Application by Highways England for A47 North Tuddenham to Easton
The Examining Authority's written questions and requests for information (ExQ3)
Issued on 30 November 2021

The following table sets out the Examining Authority's (ExA's) third written questions and requests for information – ExQ3.

Figure 2-3: Wood Lane Junction Alternative 1

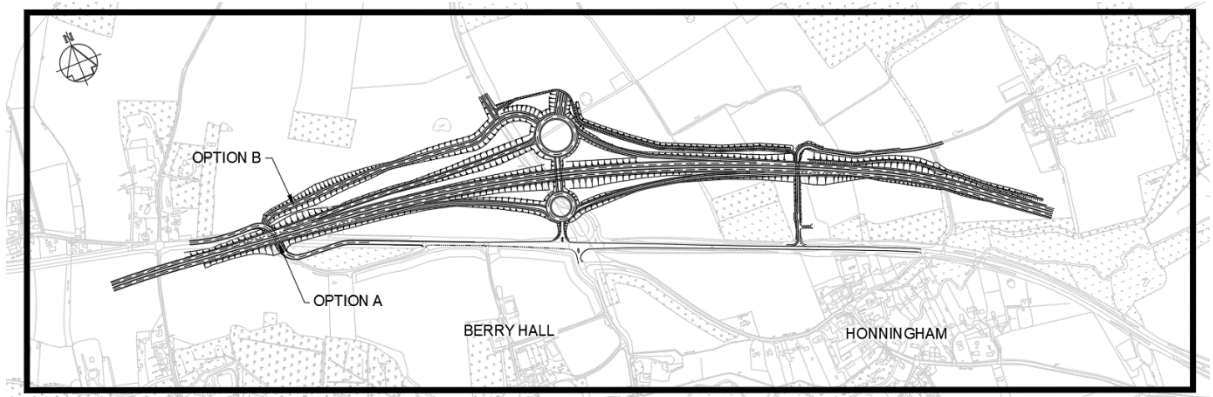
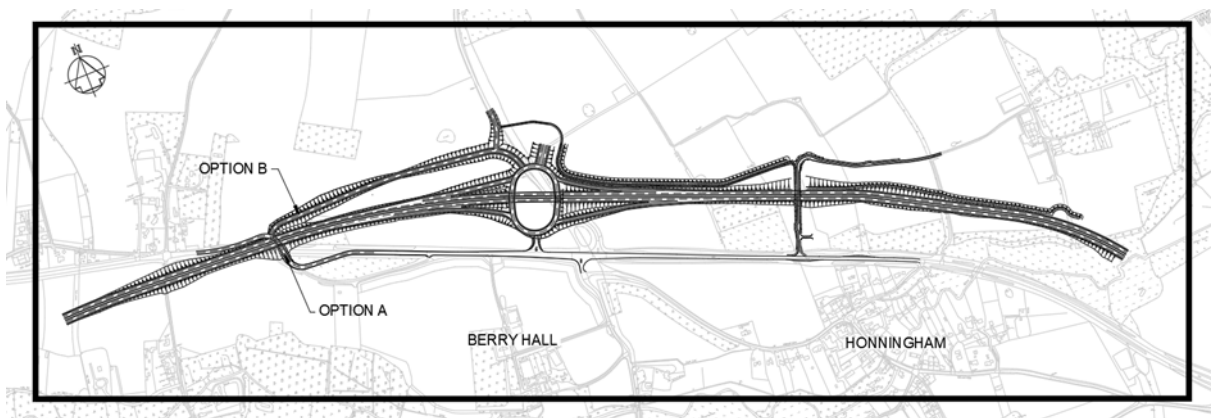
ExQ3	Question to:	Question:
Q14.3.1	The Applicant	With regards to the proposed Wood Lane junction, if the NWL is not delivered, what are the implications for the proposed junction? Would the non-delivery of the NWL result in the provision of an over-designed and over-sized junction arrangement? What options has the applicant looked at to account for the potential non-delivery of the NWL, to identify whether a reduced junction size and land take could be provided?
Q14.3.2	The Applicant	What assumptions have been made with regards to the amount, type and any seasonal timings of agricultural vehicles which currently operate in the area. How will the proposed scheme impact on these?
Q14.3.3	The Applicant	Paragraph 2.5.3 of ES Chapter 2, The Proposed Scheme [APP-041], states ' <i>The section of the A47 between North Tuddenham and Easton currently has a significantly lower morning peak average speed compared to the daily average speed along this section of the A47. This is an indicator of congestion and affects journey times and journey time reliability on the road.</i> ' Paragraph 2.5.4 then goes on to identify that these indicators show that the section of the A47 North Tuddenham and Easton is already over capacity. Please provide justification for this statement and conclusion. What is the position in the PM peak?
